**From:** Contact Centre (CRM) <contact@ribblevalley.gov.uk>  
**Sent:** 19 April 2023 13:44  
**To:** Planning  
**Subject:** Planning Application Comments - 3/2023/0223 FS-Case-509061083

**Planning Application Reference No.: 3/2023/0223**

**Address of Development:** Hillside Moor Lane Wiswell BB79DG

Moor Lane elevation

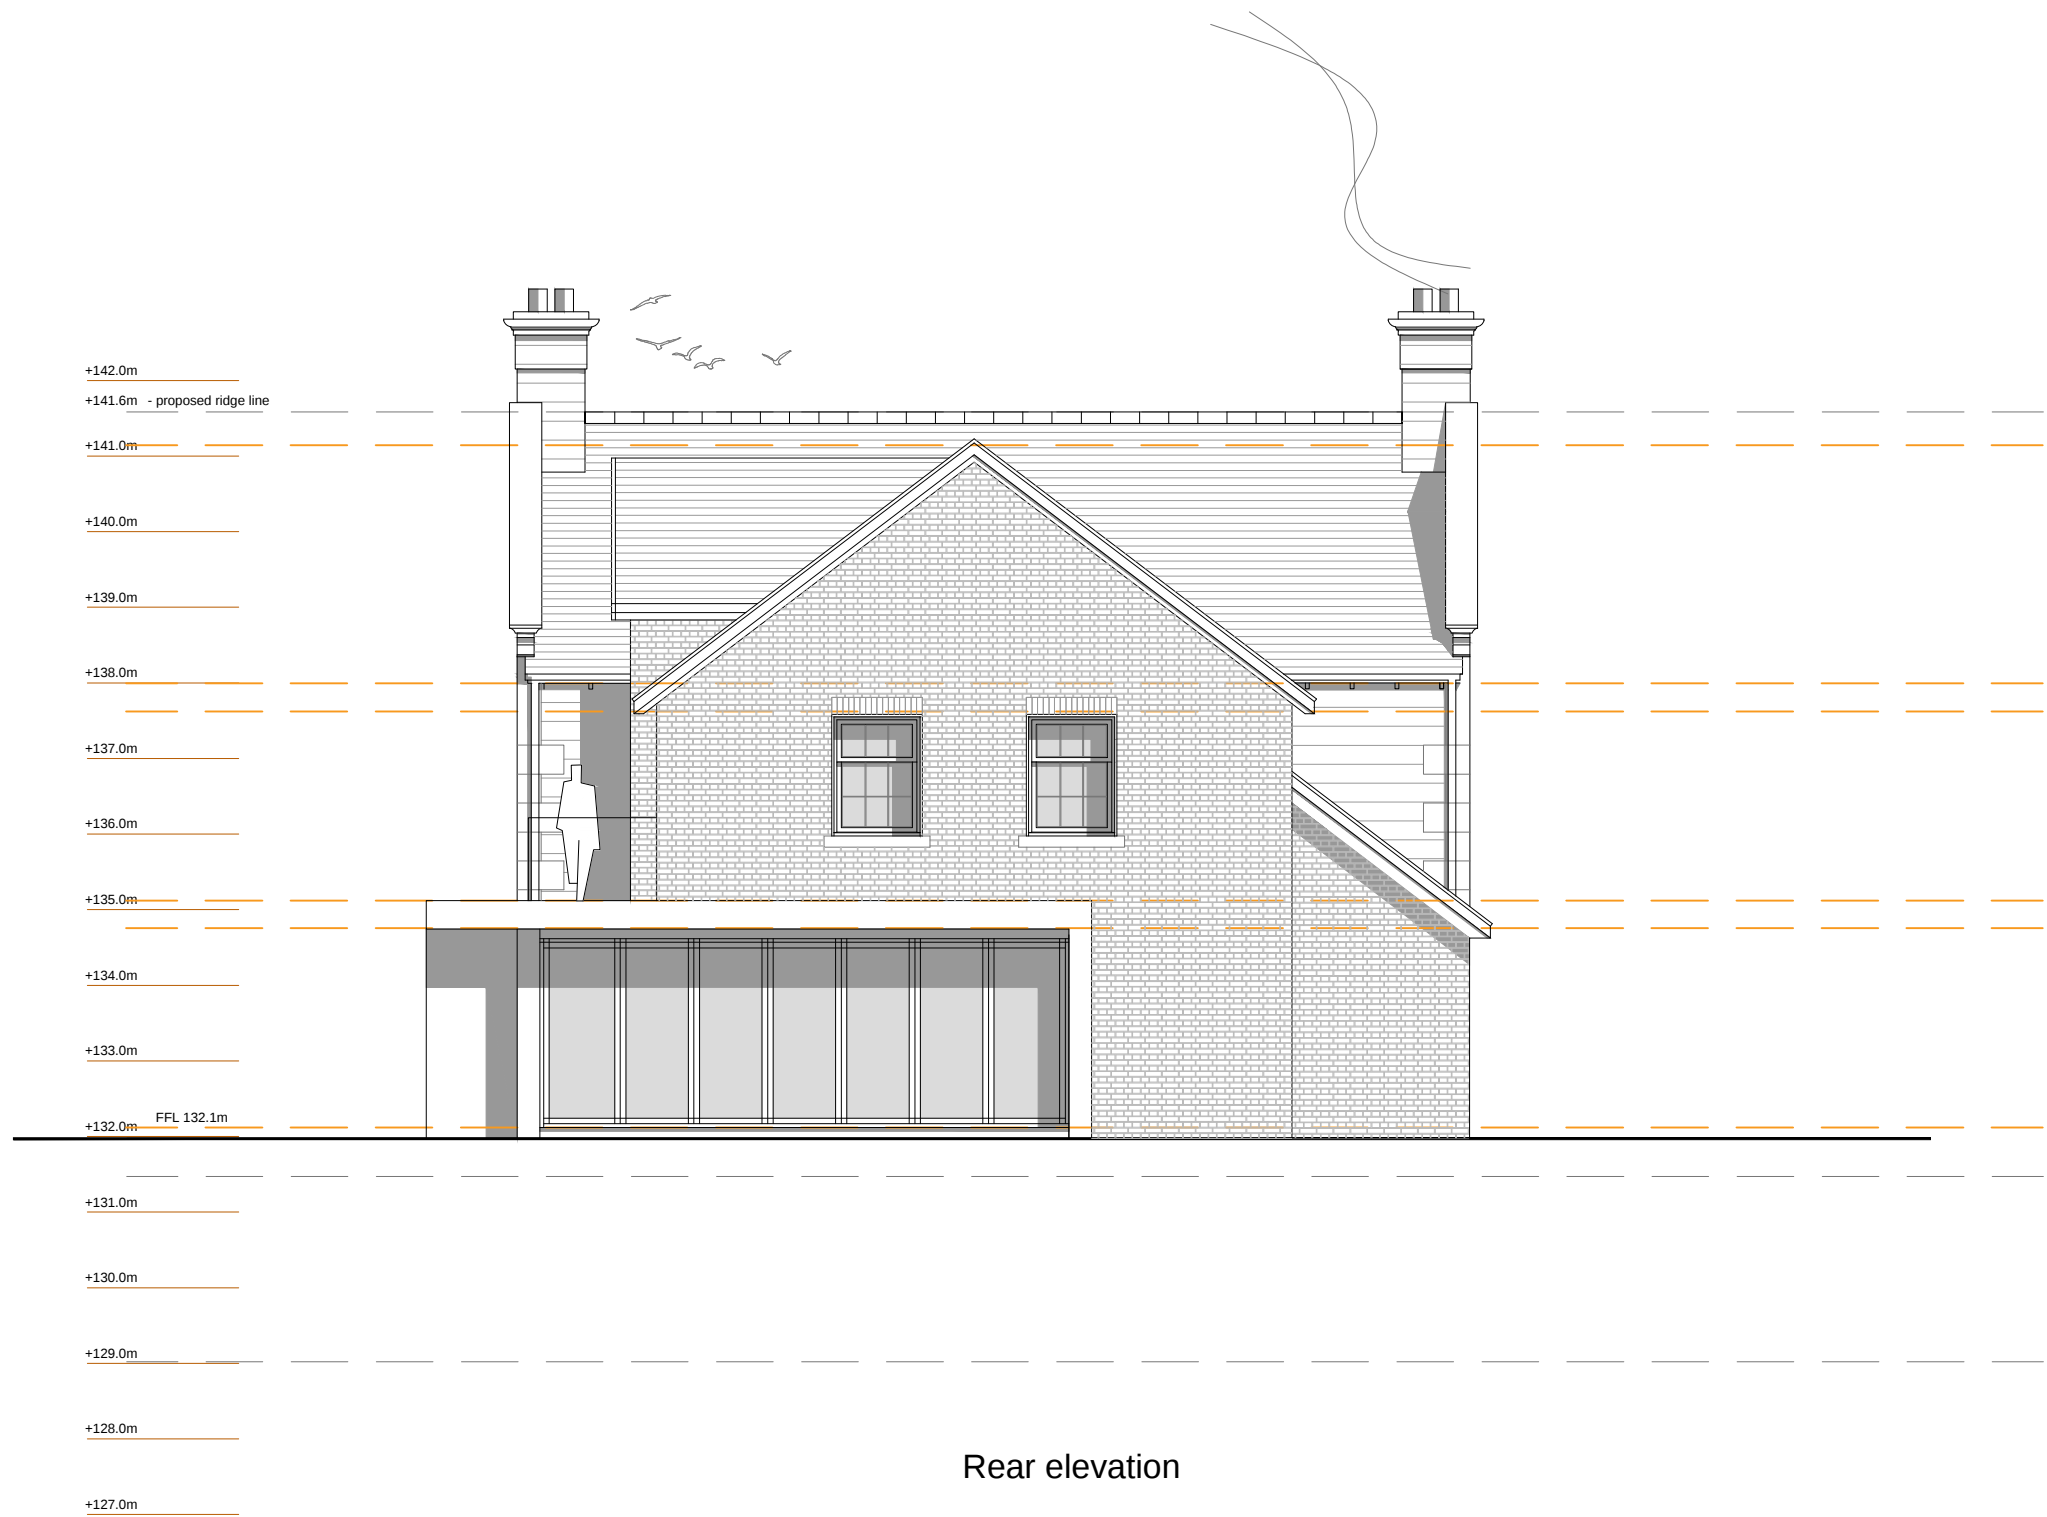
It is essential for homes to be updated and revamped but moving from a two storey to a three storey has concerns and details of the plans [REDACTED] requested.

proposed

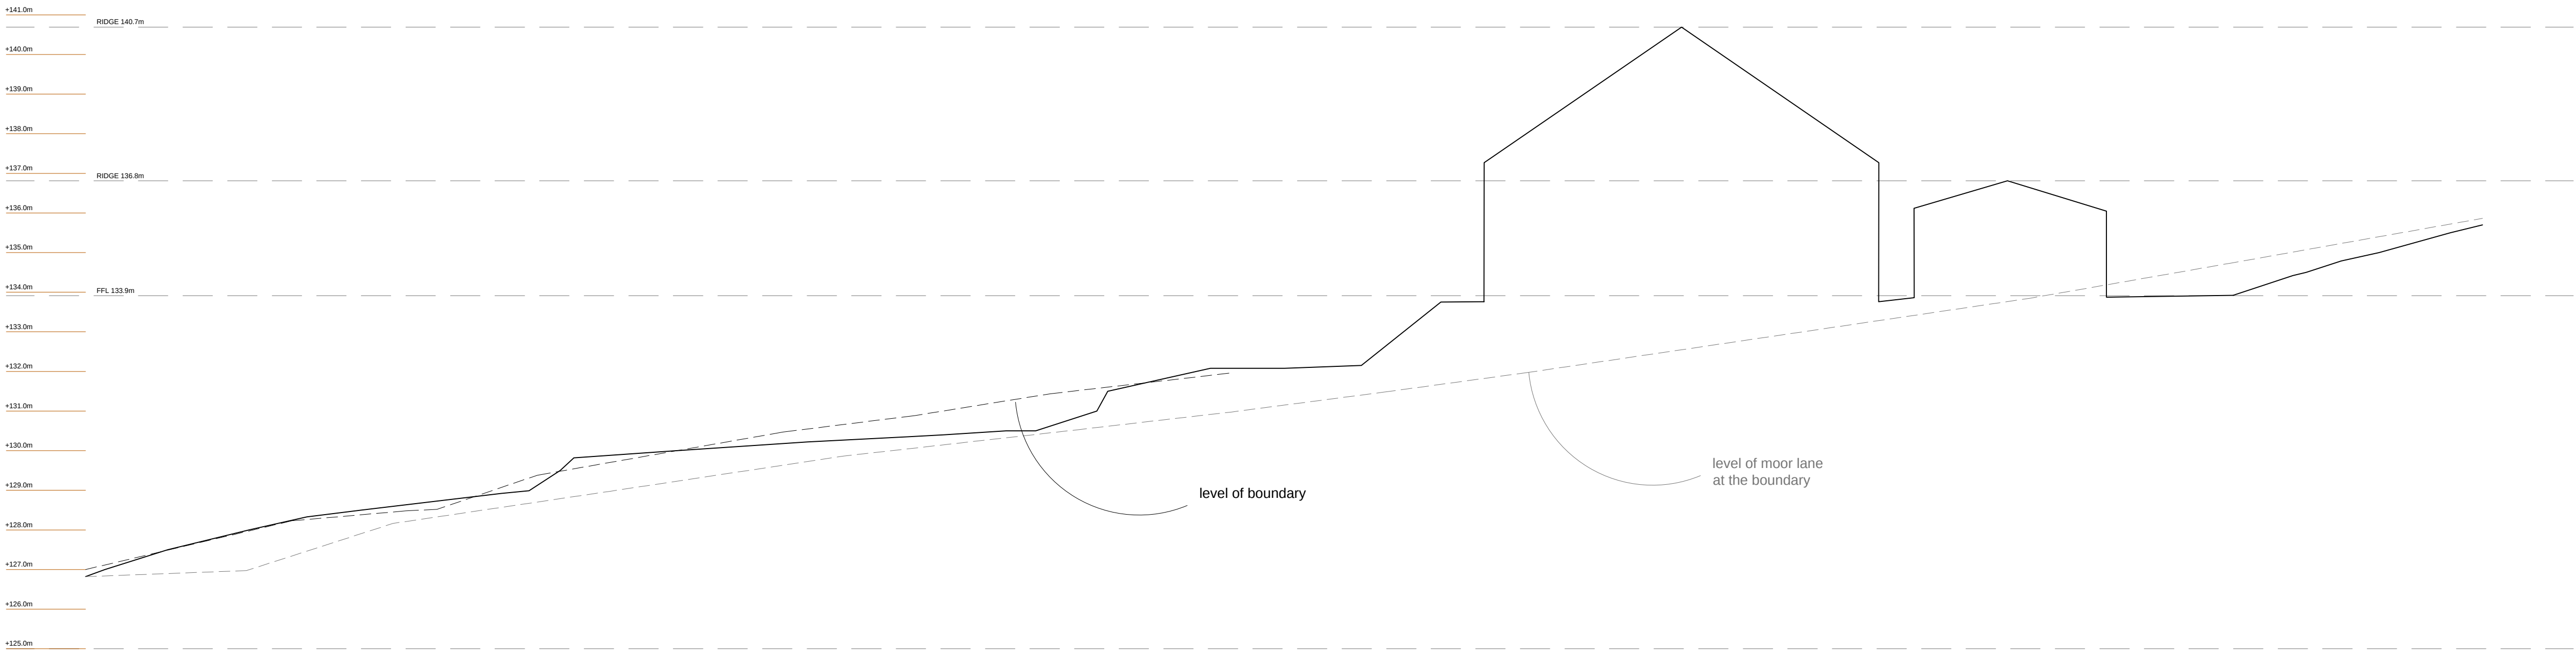
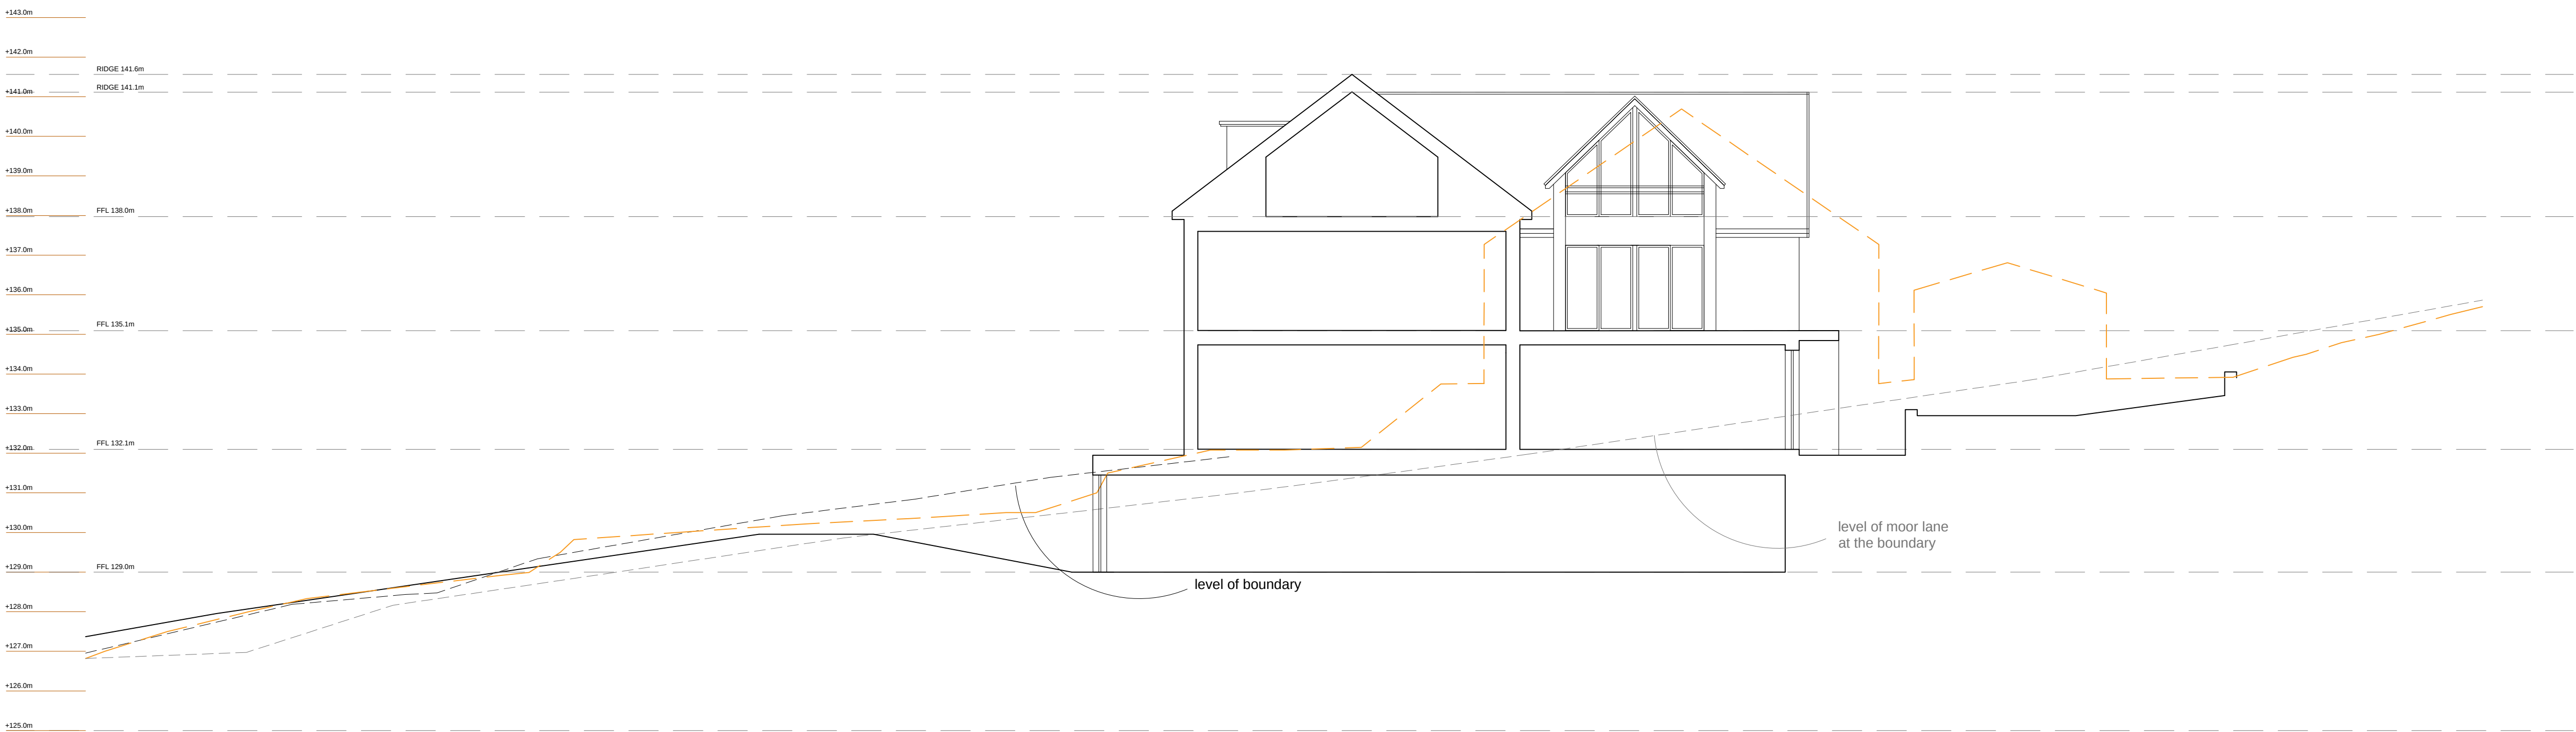
It is unclear on the plans but appears that the plan is to change the level of the road approaching the new entrance. Consideration to how this would affect the natural water course, gullies, and the brook.
